## DELEGATED HOUSEHOLDER DECISION

<b>Item No.</b>	<b>Report of the Head of Development Management and Building Control</b>	
<b>Address:</b>	12 BELMONT CLOSE UXBRIDGE	
<b>Development:</b>	Construction of a single-storey rear extension, first-floor side extension, and front porch. Conversion and alteration of roof space to habitable use, including the construction of a rear dormer and installation of three roof lights.	
<b>LBH Ref Nos:</b>	64690/APP/2024/1692	
<b>Drawing Nos:</b>	Existing GA Existing GA 2 Proposed GA Proposed GA 2 Proposed GA 3 Existing & Proposed Street Scene Site & Location Plan	
<b>Date Plans received:</b>	26-06-24	<b>Date(s) of Amendments(s):</b>
<b>Date Application valid</b>	05-07-24

DRAWING Proposed GA

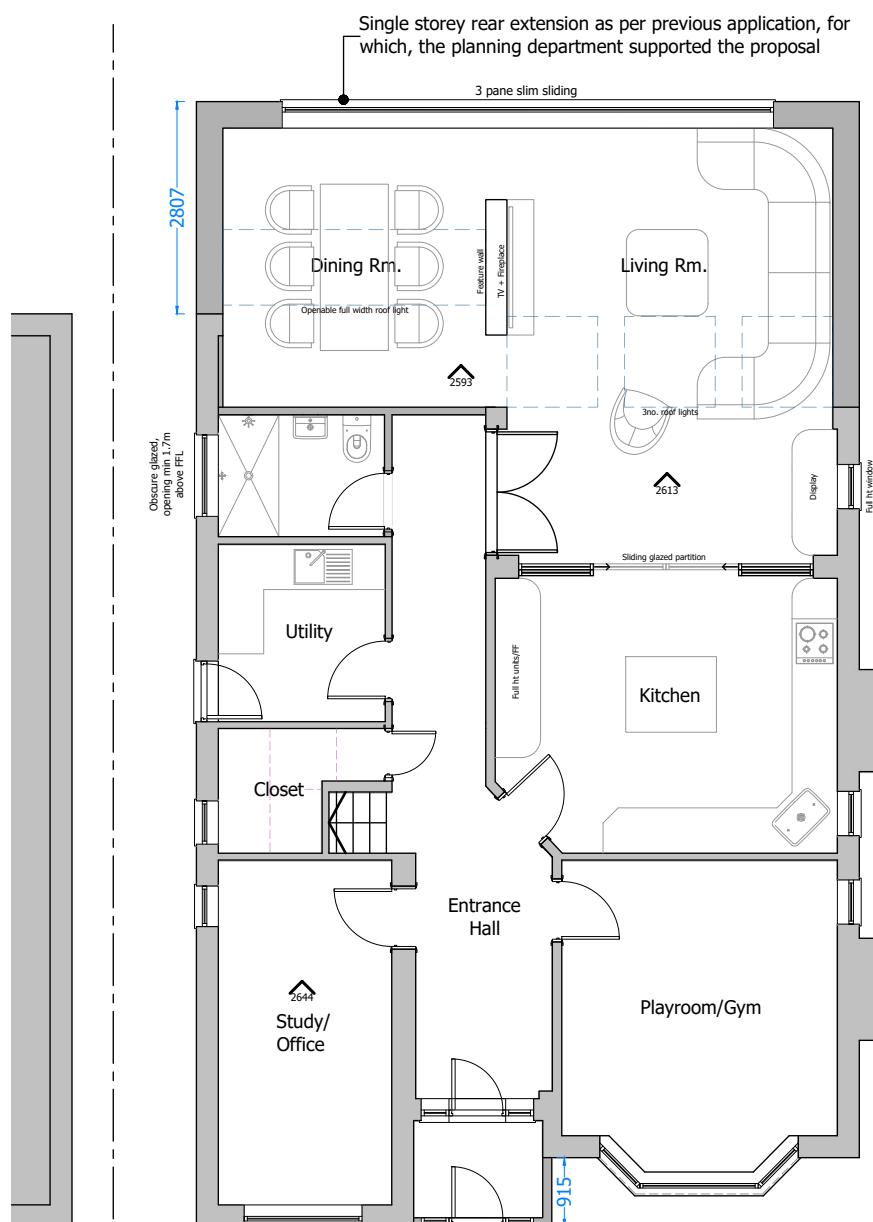
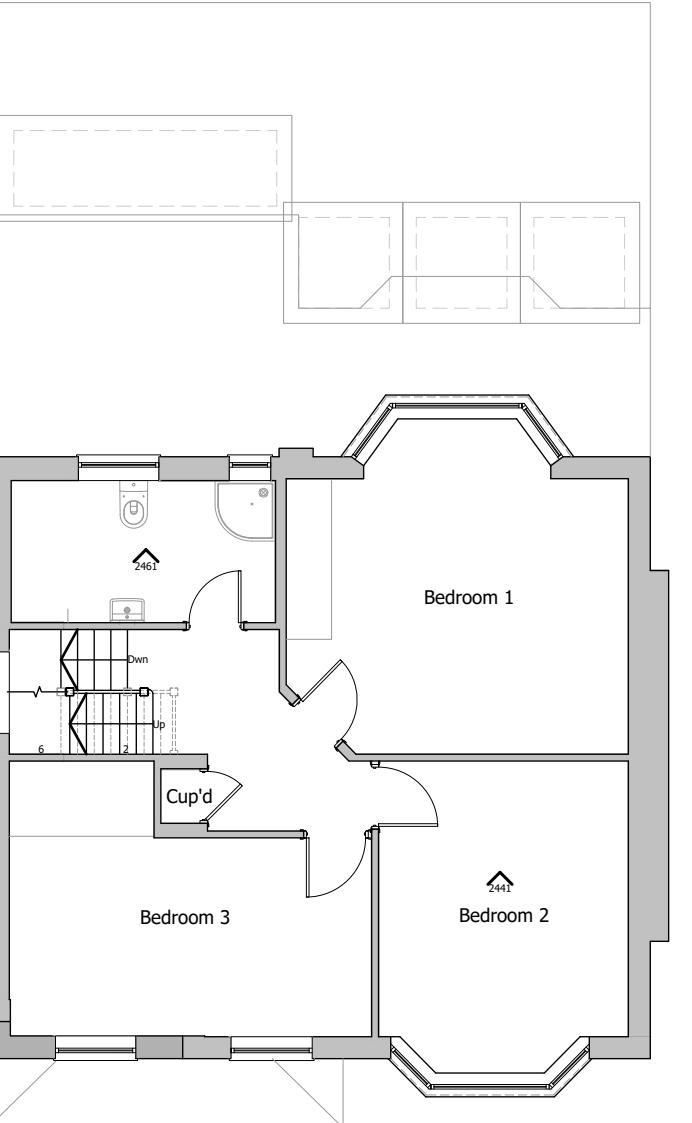
The proposed front porch/front extension would extend to the side of the existing side/front extension. It would add 2.5 sqm to the front of the property, characterised by a new pitched roof over the existing and proposed extension. It is noted that the design and size of the front extension are the same as the previous application under reference 64690/APP/2024/309, which the Council refused. However, the applicant has provided multiple examples of similar and larger front porches/extensions within the area, which are considered to set a precedent for this development. It is considered that the proposed front extension would cause some harm to the character of the original property as it would remove an existing recessed brick archway. Notwithstanding, as similar front extensions have been built in the immediate area, it is not considered that the proposed extension would be so significantly harmful to warrant refusal. It is noted that the property is located within an Area of Special Local Character. However, it is not considered that the proposed front porch would cause unacceptable harm to warrant refusal. On balance, the front extension is considered acceptable.

The proposed rear extension would be single-storey and connect to the site's existing single-storey rear structure. The total depth from the original building line would be approximately 6m. It would measure 3.1m in height, characterised by a parapet wall, and it would span the entire width of the rear elevation. Although over the prescribed depth stated in Policy DMHD 1 in combination with the existing rear additions, the extension would appear in proportion with the main house. Due to the staggering building lines along Belmont Close, it would not appear out of character within the immediate surrounding area. The extension would be built partly in brick to match the existing, and white render would be applied to the rear wall. As this is located solely to the rear, it is considered acceptable, and a condition will be added to ensure the brickwork matches the existing property.

The first-floor side infill extension would be located towards the front of the property, modestly measuring approximately 0.5m deep and 2.6m wide. This minor addition would not exceed half the width of the original property and would not extend beyond the home's existing side elevation. It would appear subordinate to the main dwelling, would respect the area's character, and is acceptable.

DRAWING Proposed GA 2

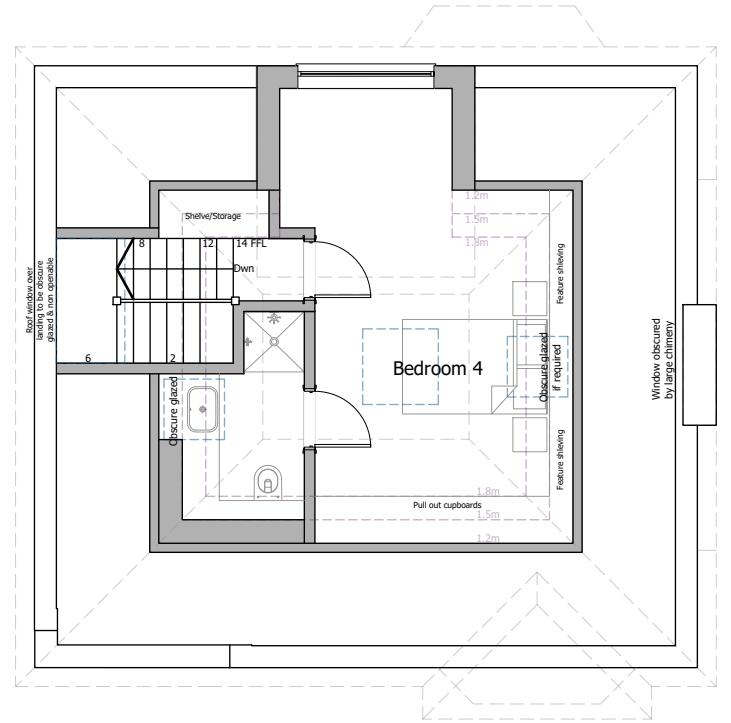
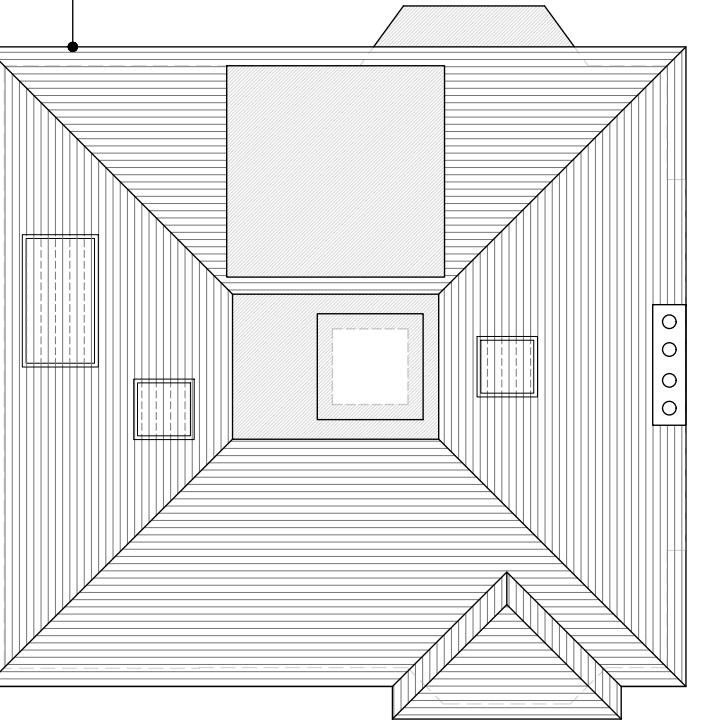
The proposed development involves works to the existing roof form and side extension. The proposed development would involve extending the front extension to align with the front elevation with a new crown roof following the removal of the existing catslide roof and the erection of a rear dormer with side roof lights. The new roof would be raised approximately 0.2m, which would not appear notably different when viewed from the street scene. The existing roof form includes a crown roof. Therefore, marginally extending this element is not considered harmful. Although the side extension being brought forward is not compliant with Policy DMHD 1, which requires side extensions to be set back and set down, it is noted that properties along Belmont Close benefit from large side extensions of a similar design, notably 17 Belmont Close has recently had an approval for a double-storey side extension and roof works under application reference 30507/APP/2023/2518 which is similar to the proposed scheme.

The proposed rear dormer would be set down from the main ridgeline and measure approximately

2.9m in width, 2.7m in depth, and 2.5m in height, characterised by a flat roof. It would be set up from the eaves and set in from the side boundaries. It is considered that the dormer would fit comfortably on the rear roof slope and would not cause harm to the character of the original property. As it is located to the rear, it would not be readily visible from the street scene and, as such, would not cause harm.

The development would include roof lights on the side roof slopes; these would serve a stairway and the fourth bedroom. It is not considered that these would cause harm to the character and appearance of the main dwelling or the Area of Special Local Character.
